Subject: MOD 1 – Yarrabee Battery Storage and Transport Route (SSD 9237 Mod 1)

Detailed comments on Yarrabee Battery Storage and Transport Route (SSD 9237 Mod 1)

Comments on Appendix D Heritage Review prepared by OzArk (November 2019)

Comments on Appendix G: Heritage Assessment – Eulo Road and Kidman Way Proposed Intersection Upgrade prepared by OzArk (November 2019)

Figure 5-36: Recorded sites within Project Area and impact footprint.

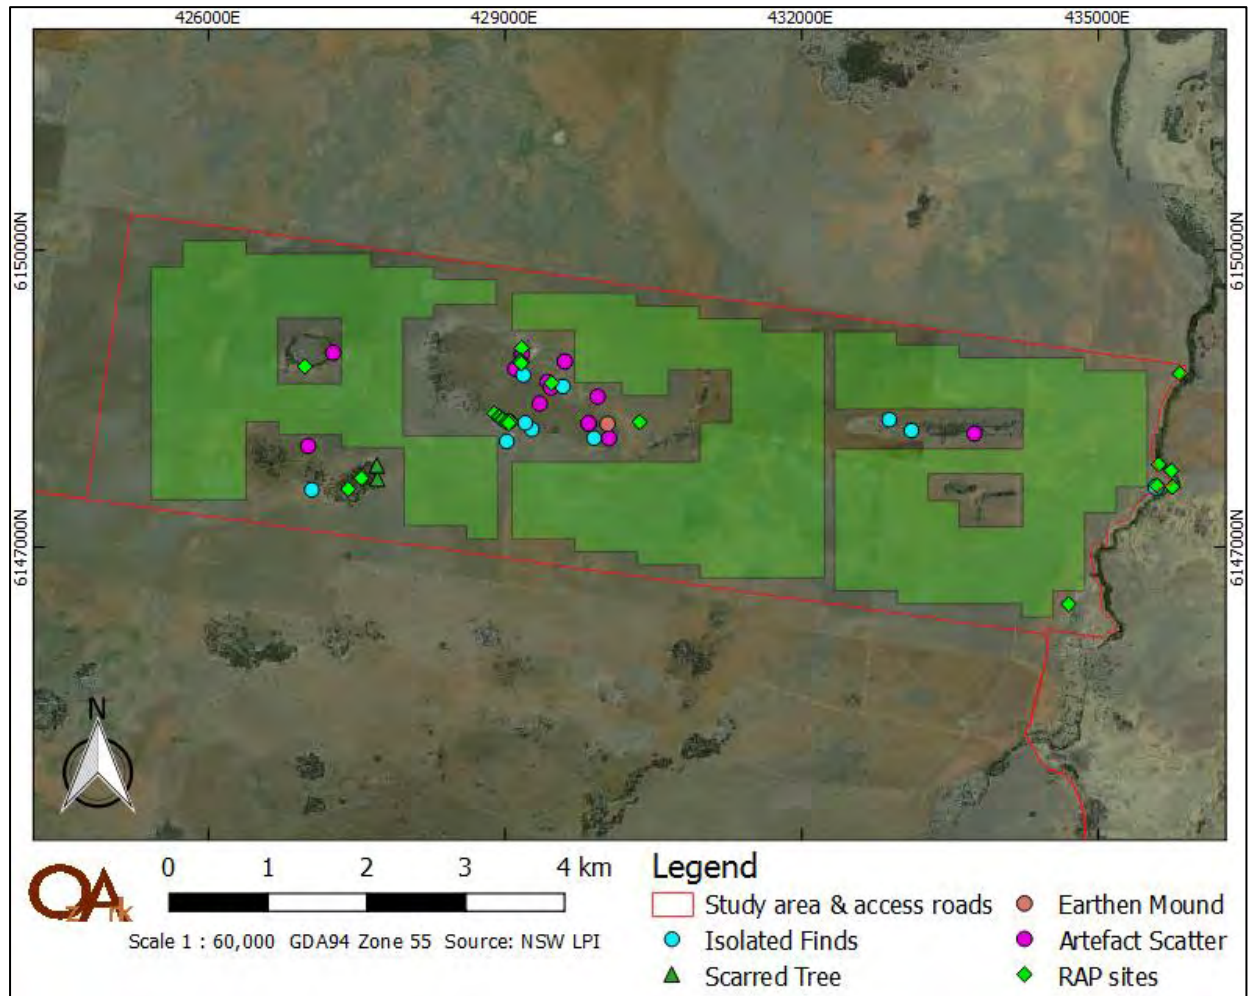
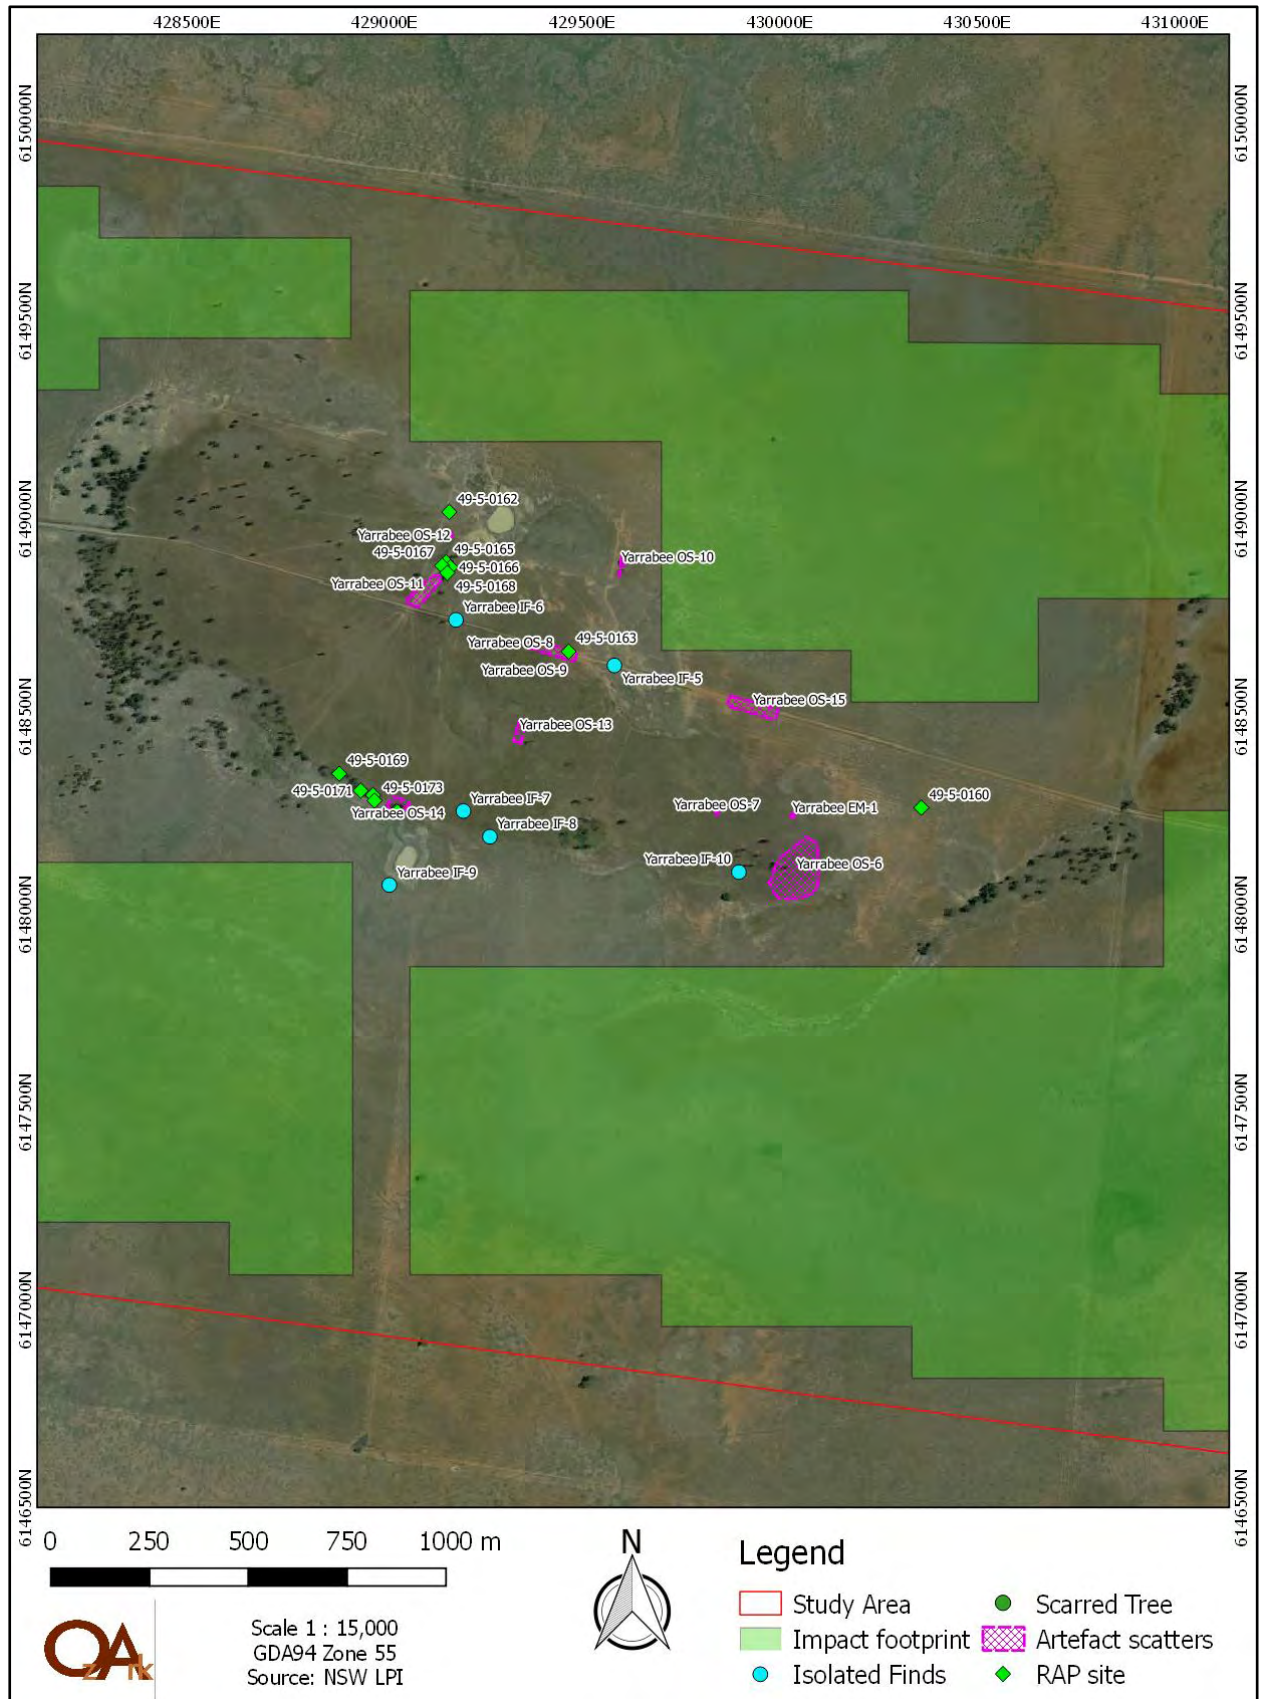
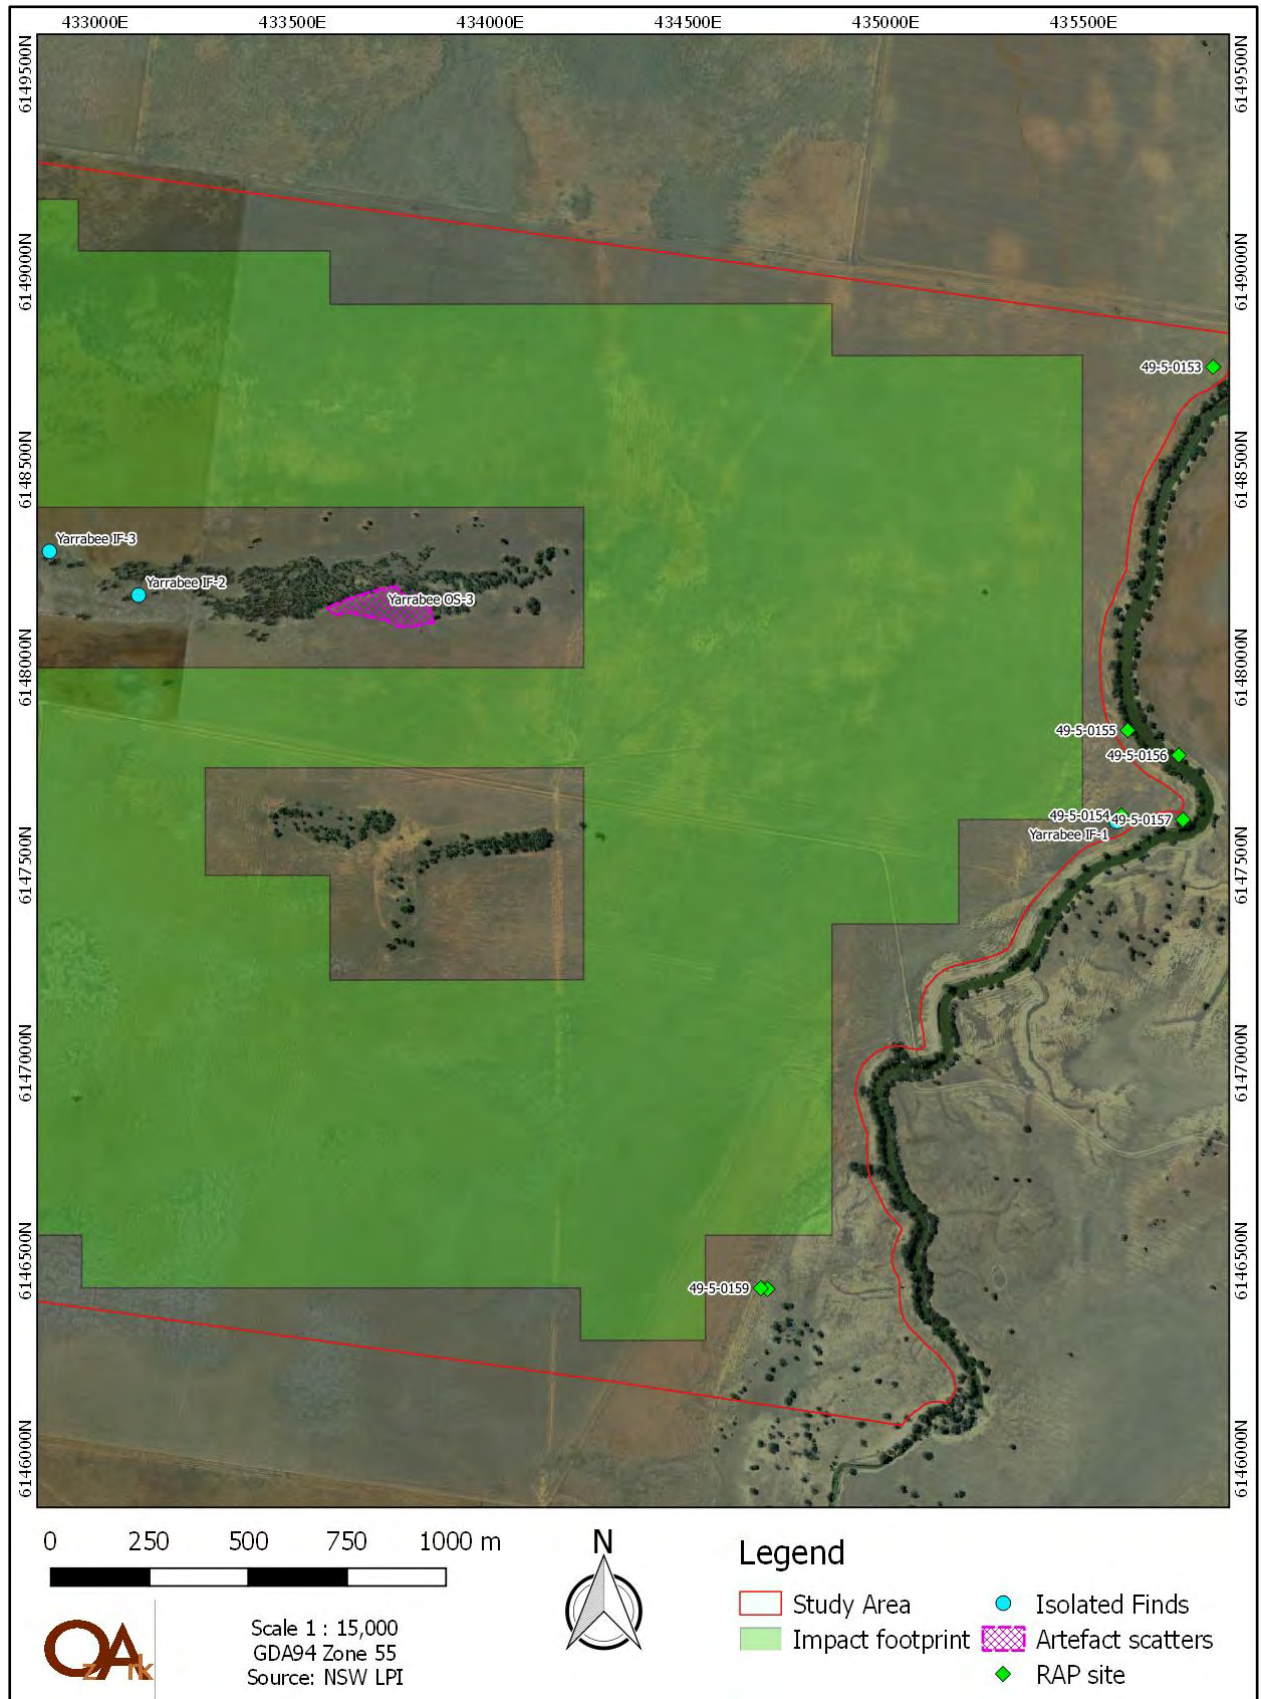
It is not clear if the Modification Assessment complies with Condition of Consent Schedule 3 Condition 16. This condition provides protection to Aboriginal heritage items as follows: “The Applicant must ensure the development does not cause any direct or indirect impacts on Aboriginal heritage items identified in Table 1 in Appendix 4 or located outside the approved development footprint”.

- To ensure the new works comply with condition 16, the applicant undertake an impact assessment of the works associated with the modification against the known Aboriginal heritage items, particularly those in Table 1 in Appendix 4.
- We request a copy of the impact assessment be provided to the Biodiversity and Conservation Division for comment.
- A copy of Appendix D including the impact assessment against Aboriginal heritage items in Table 1 above be provided to the Registered Aboriginal Parties (RAPs) identified for the Yarrabee Solar Farm for their information and comment.
